**KIRKLEES METROPOLITAN COUNCIL
INVESTMENT & REGENERATION SERVICE**

**DELEGATED DECISION TO DETERMINE APPLICATIONS FOR
NON-MATERIAL AMENDMENTS**

Reference No: **2026/NM/91074/E**

Description: Non material amendment to previous permission
2023/92812 for erection of one detached dwelling

Drawing Number:
24-042-SK11

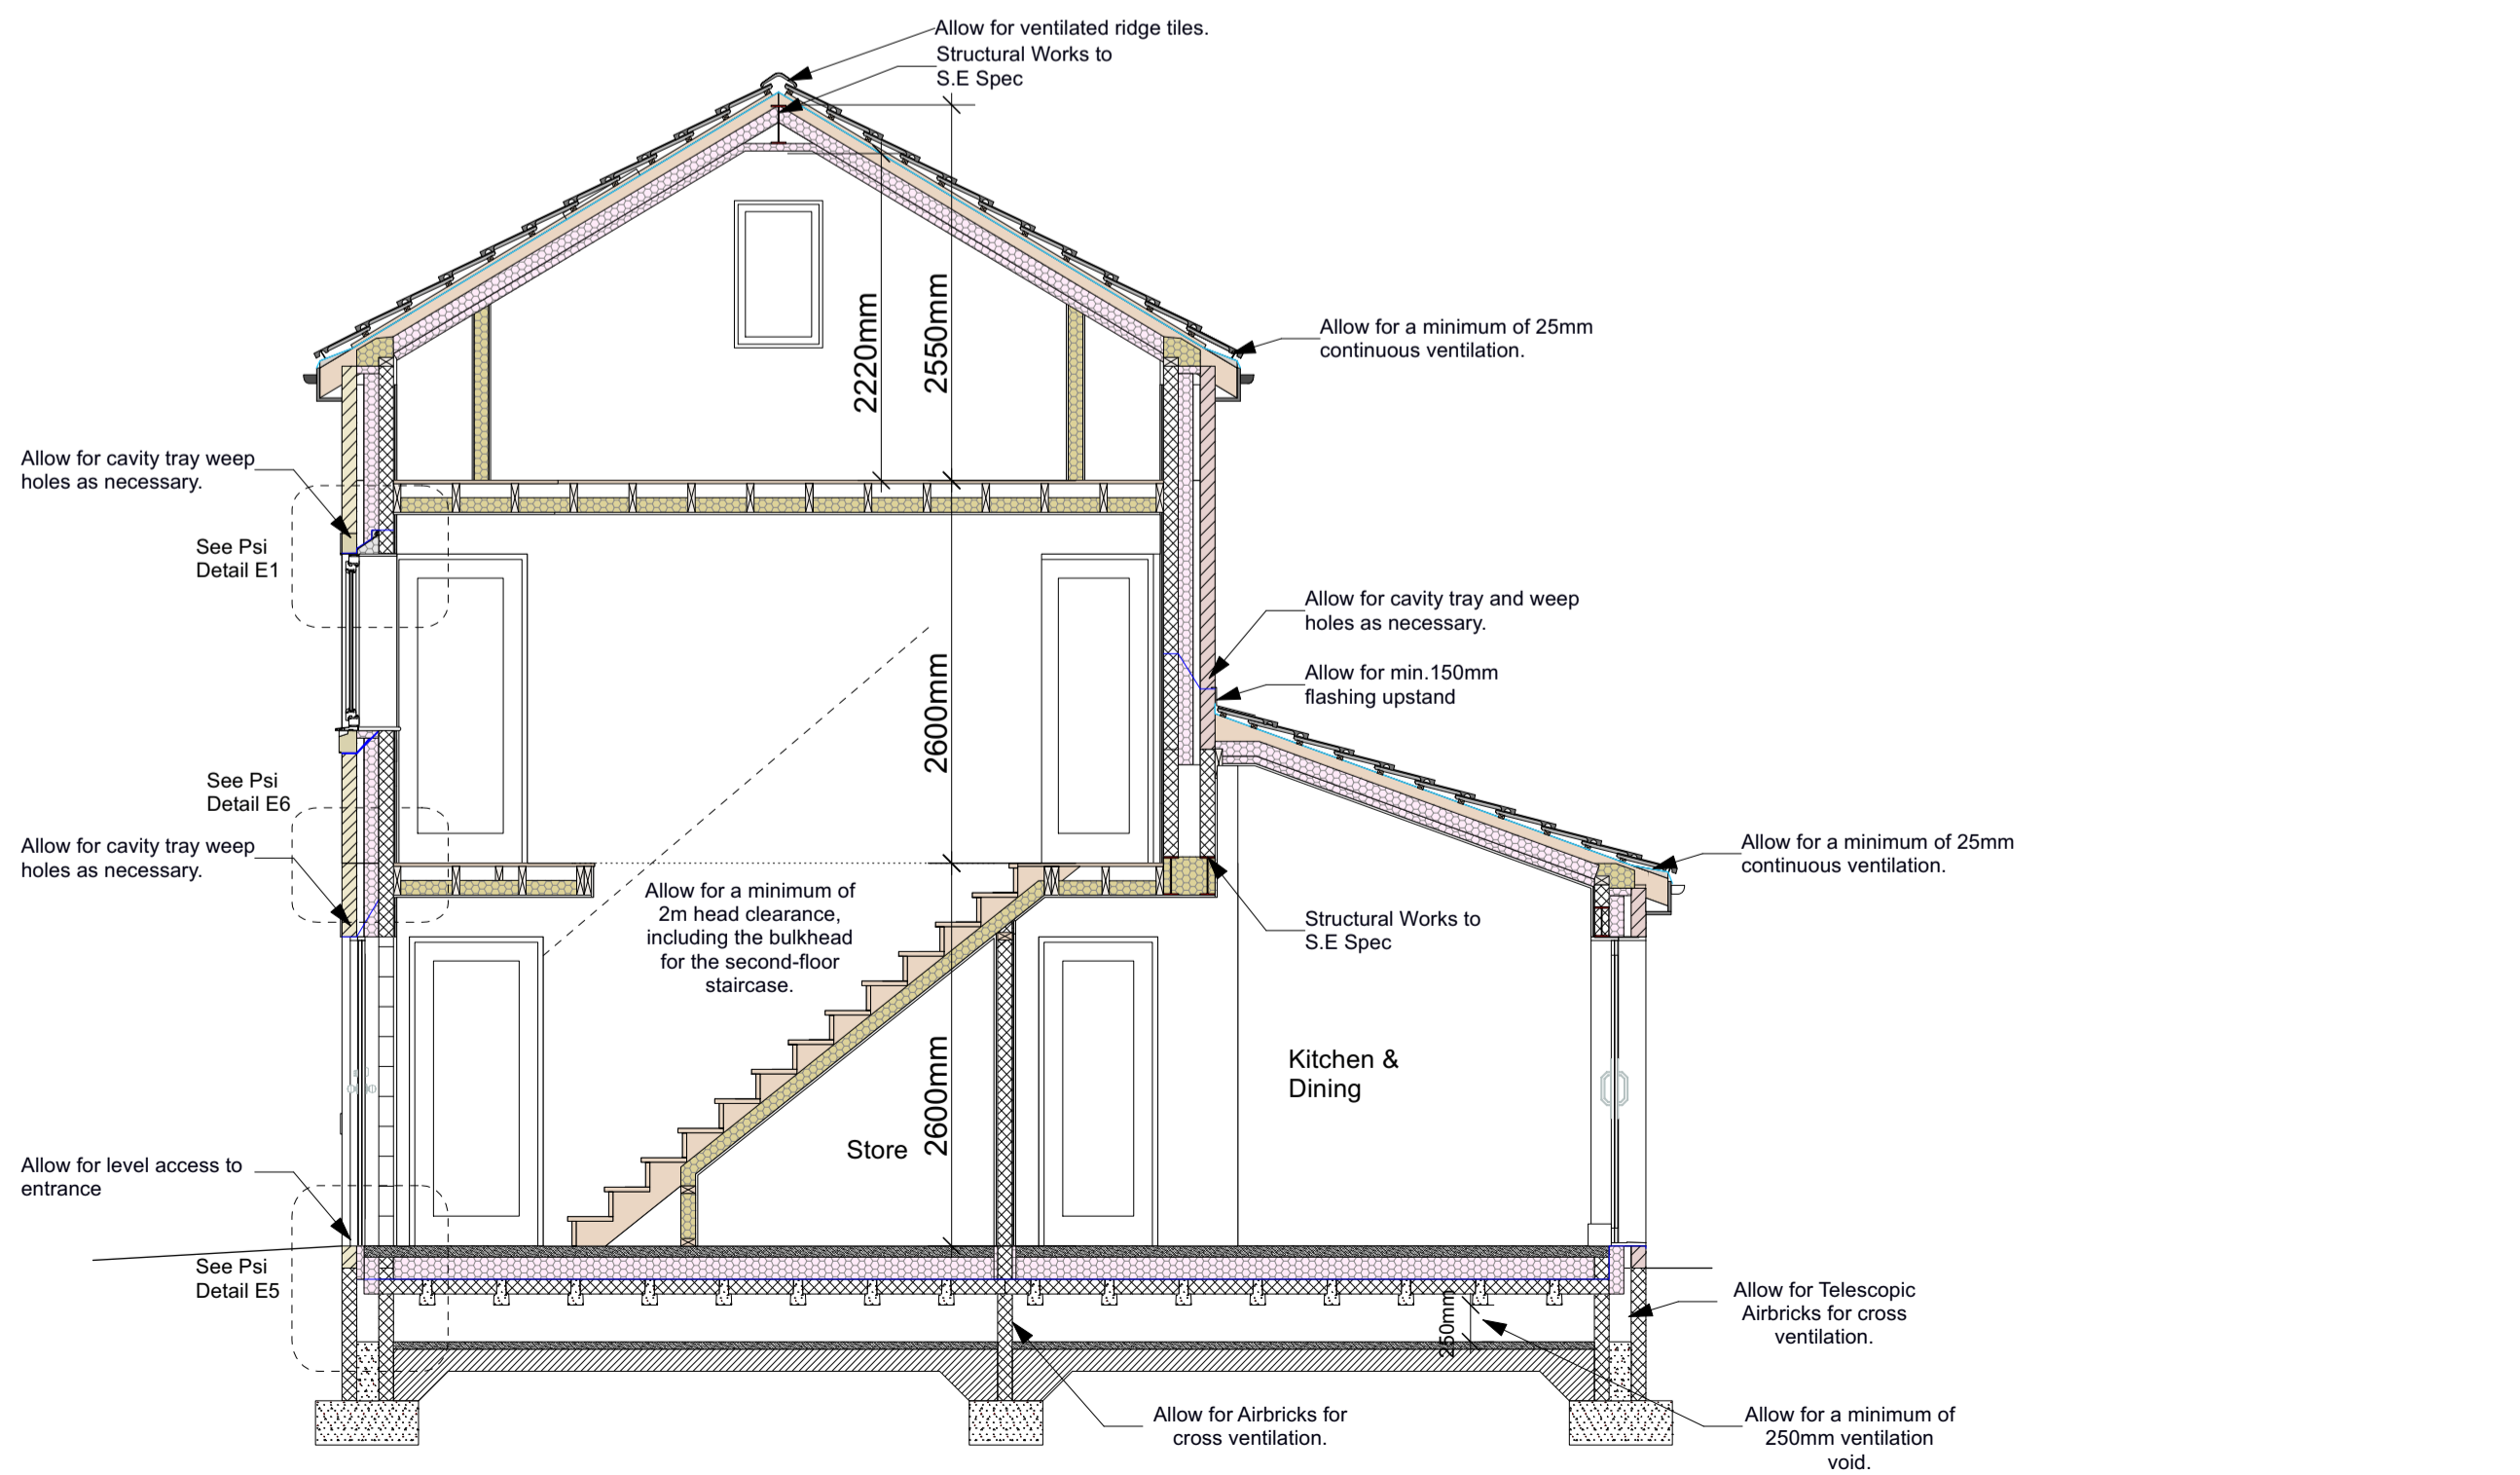
Overview: The applicant seeks a non-material amendment to amend the external materials of the approved building. The original plans showed render to the side elevations and this application seeks to amend the scheme replacing the render with brick to match the rear elevation. Plans titled 'Section & Elevations As Proposed drawing reference 24-042-SK11' have been received showing the alteration.

2. Would the change result in a detrimental impact either visually or in terms of living conditions? No, the use of brick to the sides would be in keeping with the character of the area.
